**KIRKLEES COUNCIL
TOWN AND COUNTRY PLANNING ACT 1990
HIGHWAYS DEVELOPMENT MANAGEMENT**

PLANNING REF 2018/62/91490/E0/LC
CATEGORY Minor

PROPOSAL DEMOLITION OF NURSING HOME AND ERECTION OF 8 DETACHED DWELLINGS WITH ASSOCIATED LANDSCAPING, BOUNDARY TREATMENT AND VEHICULAR ACCESS

LOCATION HOLME HOUSE CAR HOME
OXFORD ROAD
GOMERSAL
CLECKHEATON
BD19 4LA

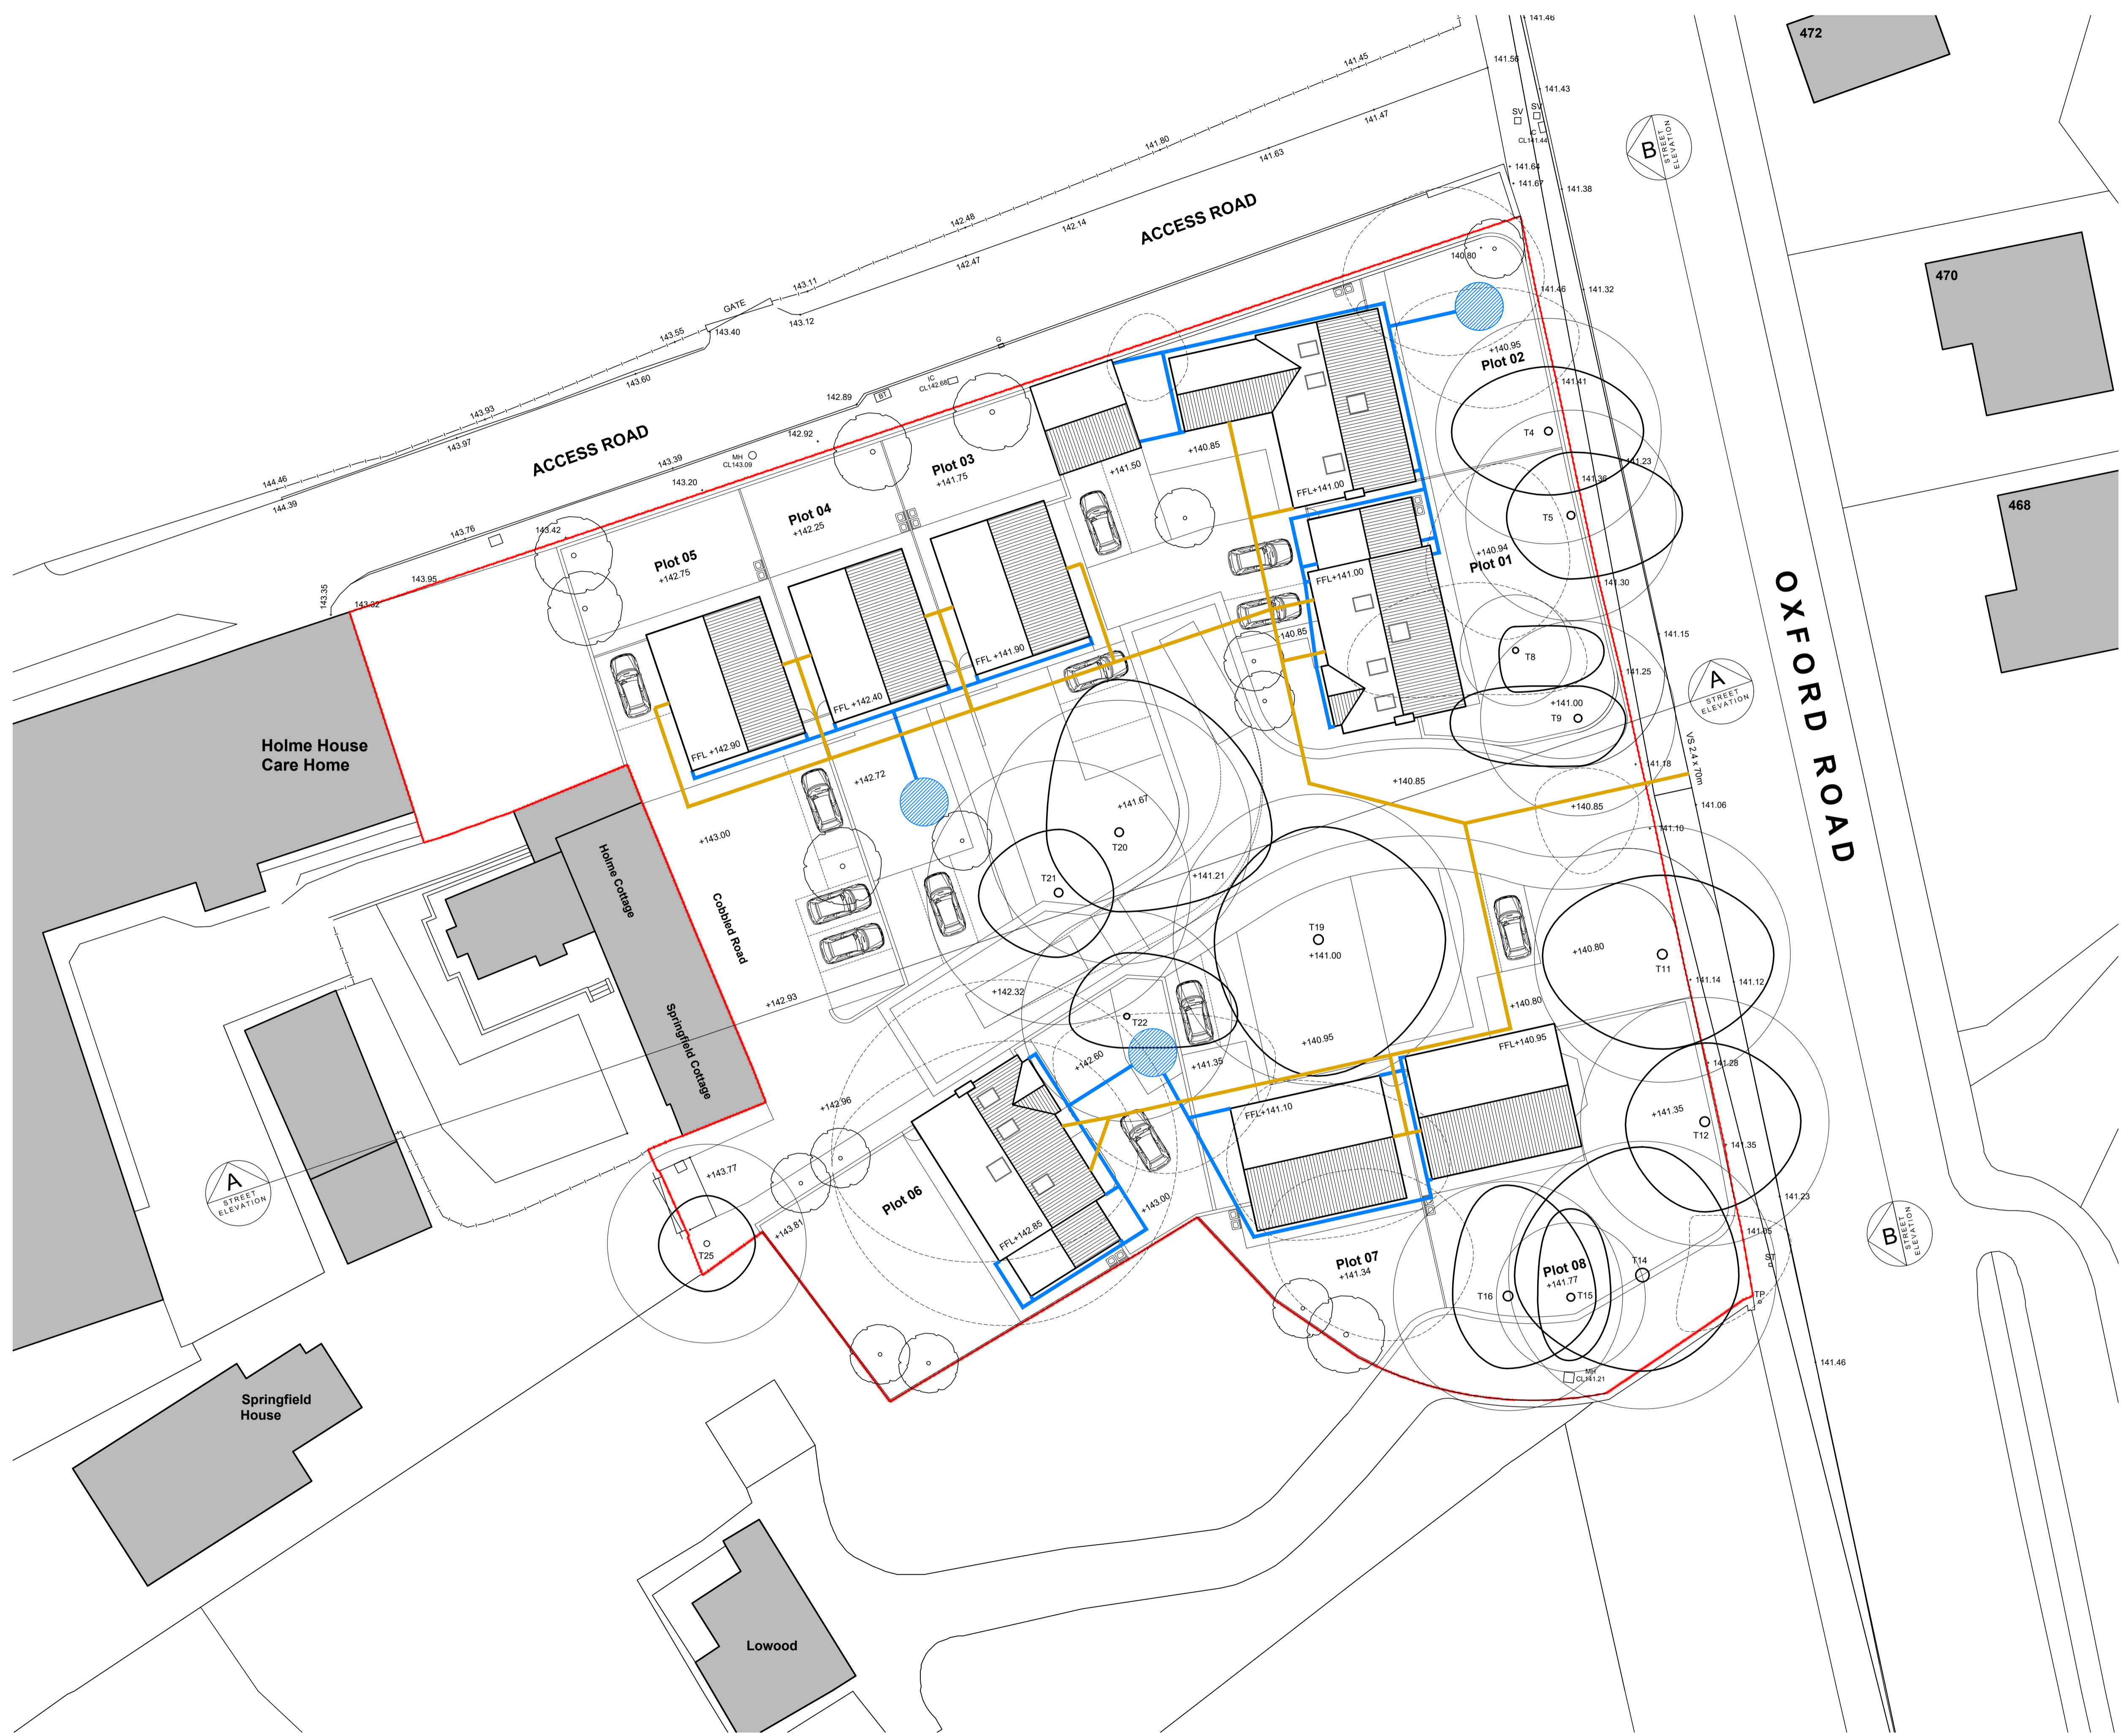
The swept paths shown on the layout plan are for a vehicle 7.5m in length. The turning head as proposed is unlikely to be sufficient in size to accommodate an 11.85 m refuse vehicle. The design of the turning head will need to be amended and swept paths provided to demonstrate that an 11.85m vehicle can enter from Oxford Road and turn and exit the proposed development.

Plots 7 and 8 have 4 bedroom and only 2 off-street parking spaces. 3 off-street parking spaces should be provided to dwellings of this size.

Bin collection points need to be shown to each dwelling which should be positioned to allow bins to be

presented for collection without obstructing the adoptable highway.

Keep clear marking should be shown to be provided on Oxford Road across the site access to assist vehicles turning right into the site.

The existing directional signing within the footway to the site frontage should be shown on the plans. It is not clear whether or not these may need to be re-positioned to accommodate the proposed site access.
